Application number: 2025/92713	
What is the application for?:	Reserved matters application pursuant to outline permission 2023/92079 for erect
Address of the site or building:	Rear of, 23 to 43, Moor Lane, Gomersal, Cleckheaton, BD19 4LF
Postcode:	LS10 1NB

## Re Preliminary Works associated with the Proposed Development

Drawing Number: 2539-D-20-002 - H
 Revision: -
 Do not scale from this drawing. Work to original dimensions, and any discrepancy to be reported to the AHJArch.
 Refer to larger scale drawings where available.

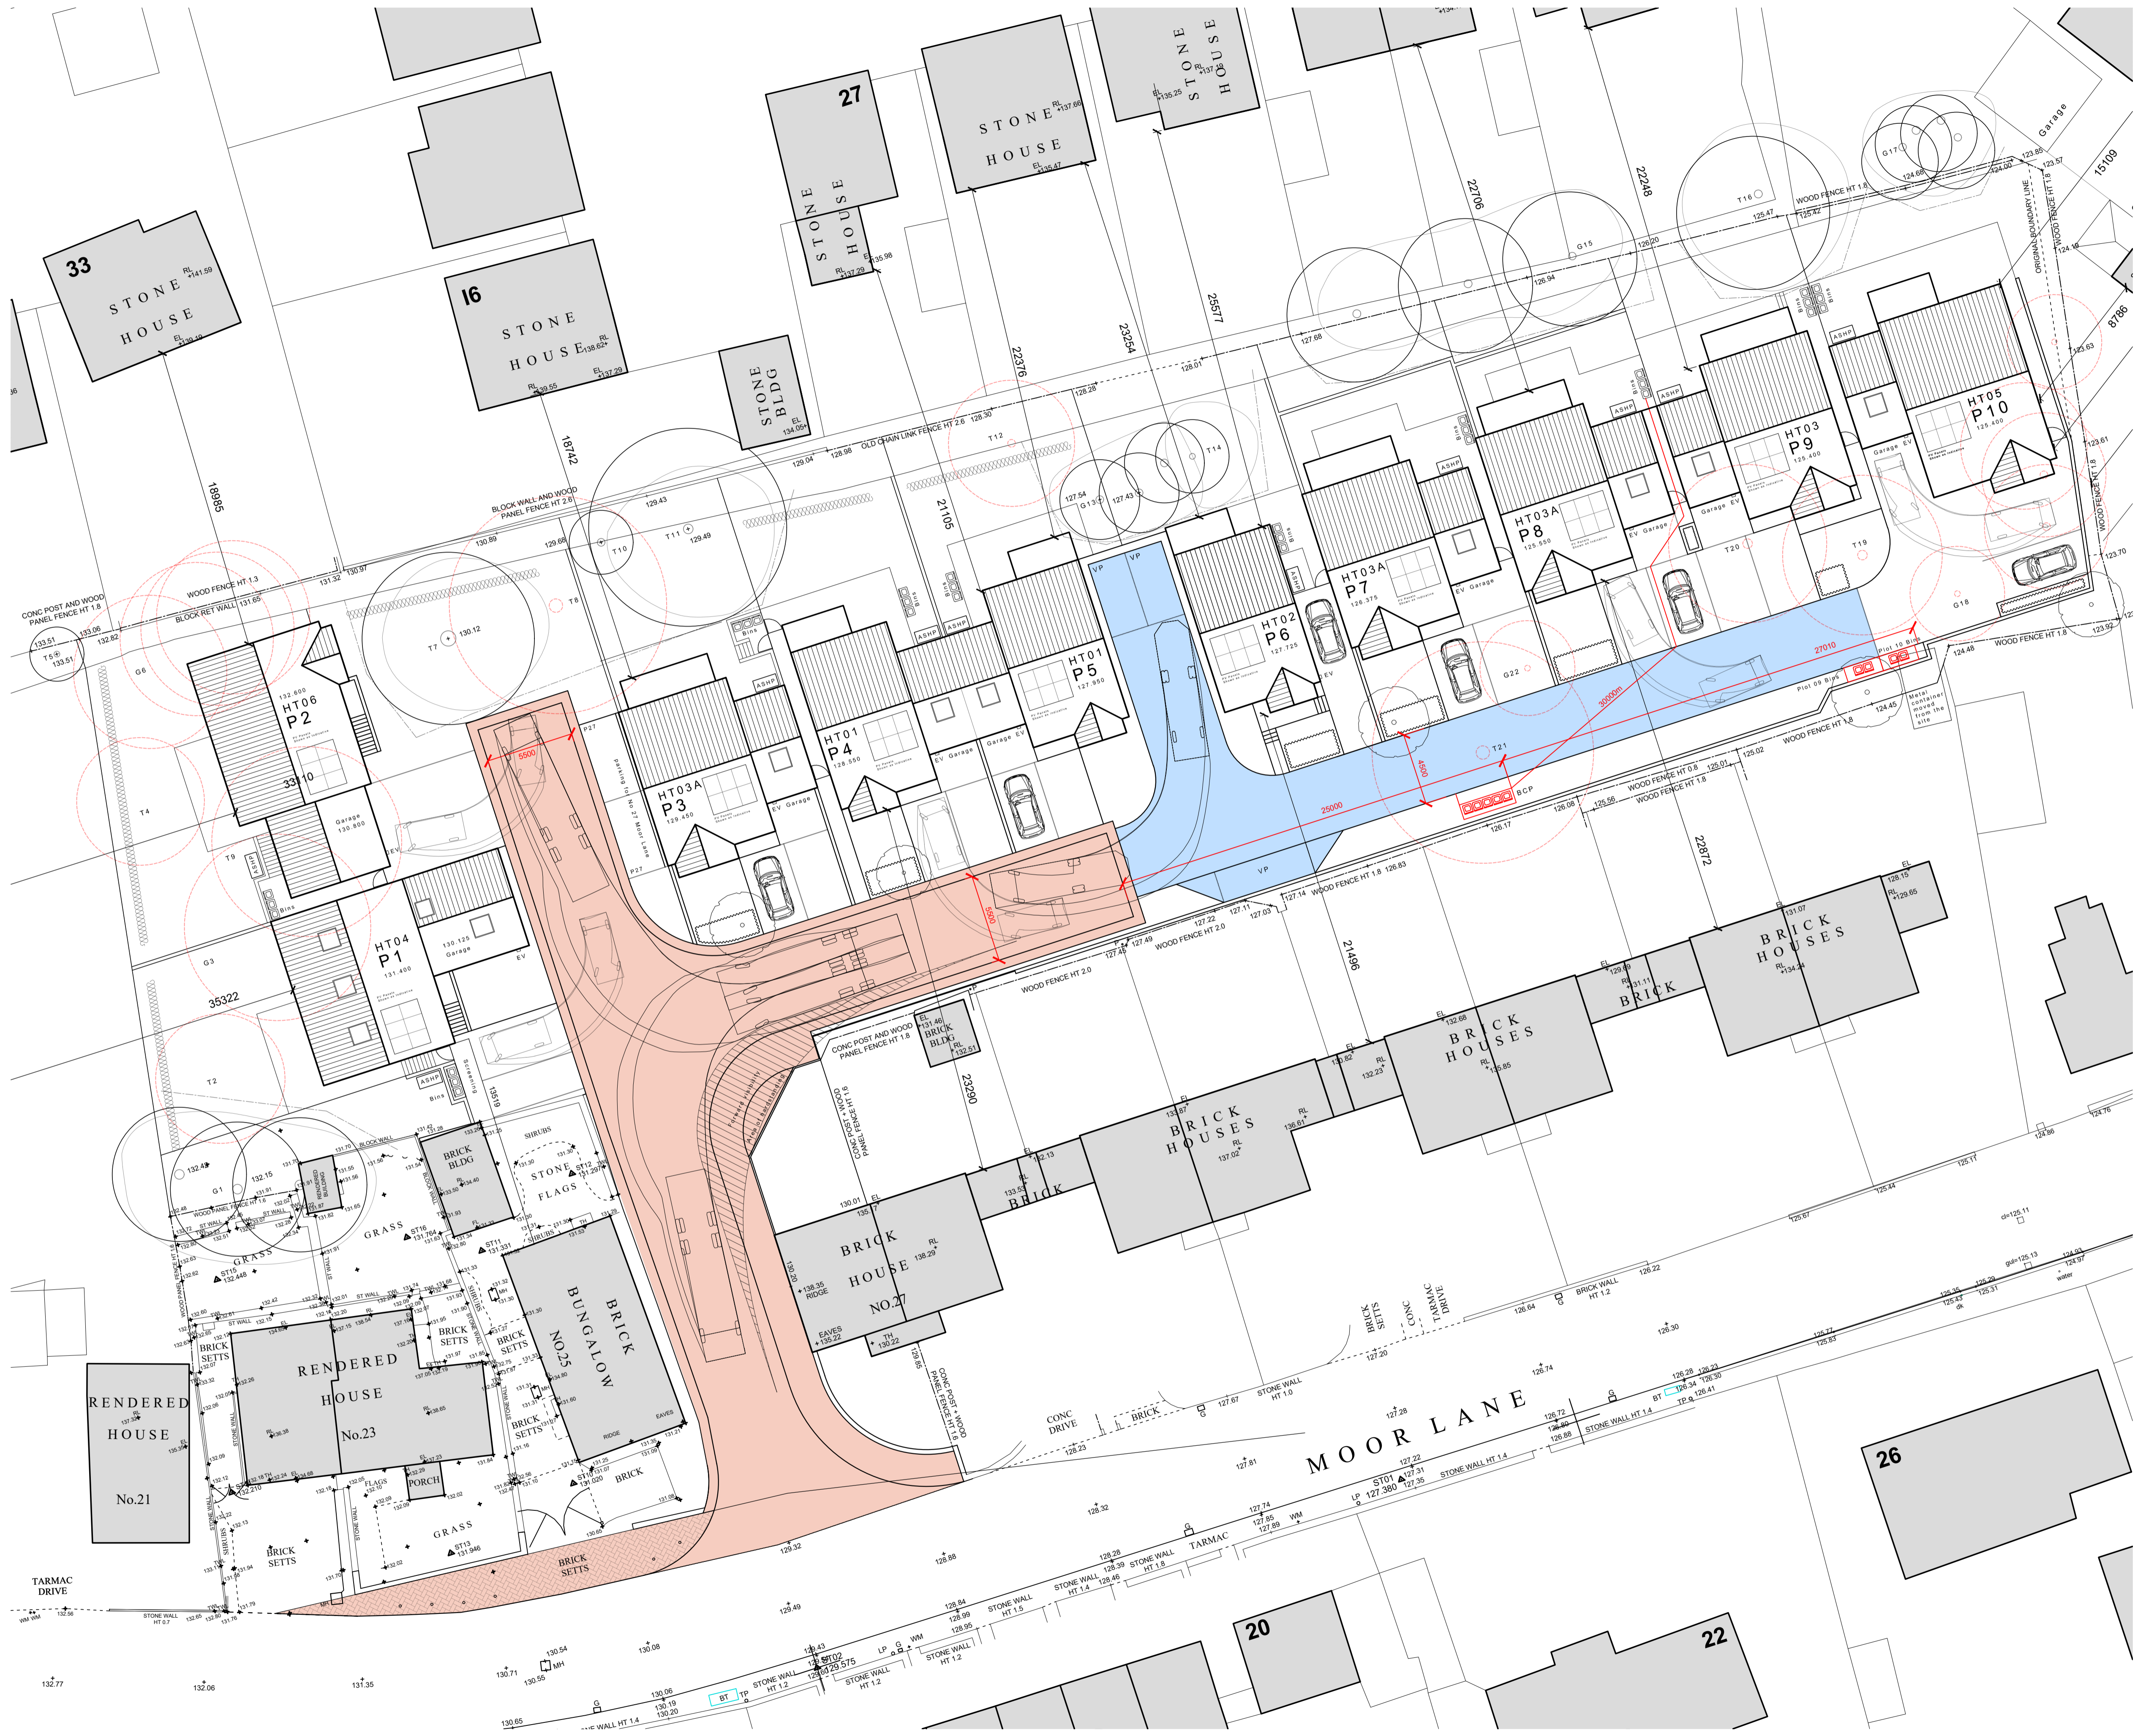
It appears that despite the detailed proposals which were approved on 5th Dec 2023 ( Application Number: 2023/60/92079/E) the 2.4 x 33 metre visibility splay for viewing traffic heading up Moor Lane appears not to conform to the specification, and also it doesn't appear to work for the following reasons:-

1 - The actual visibility splay as it passes over the reduced width garden of 27 Moor Lane appears to be compromised by the boundary wall and shrubbery of the adjacent garden of 29 Moor Lane.

The latest plan by AHJ Architects - 2539/20/002 Revision C dated 08/2025 clearly shows the visibility line encroachment over 29 Moor Lane.

As this is the private garden of a third party property it is unlikely that permission to alter their wall and shrubbery will be given. As such, the splay does not conform to regulations in that the visibility is compromised.

2 - The visibility splay is also flawed because it assumes that vehicles travelling up Moor Lane are on the left hand side of the road, when in fact they are straddling the centre line due to all the parked cars belonging to the residents of the properties opposite the proposed development.

Because vehicles are straddling the centre line, they are less likely to be seen by drivers pulling out of the development, increasing the risk of accidents.
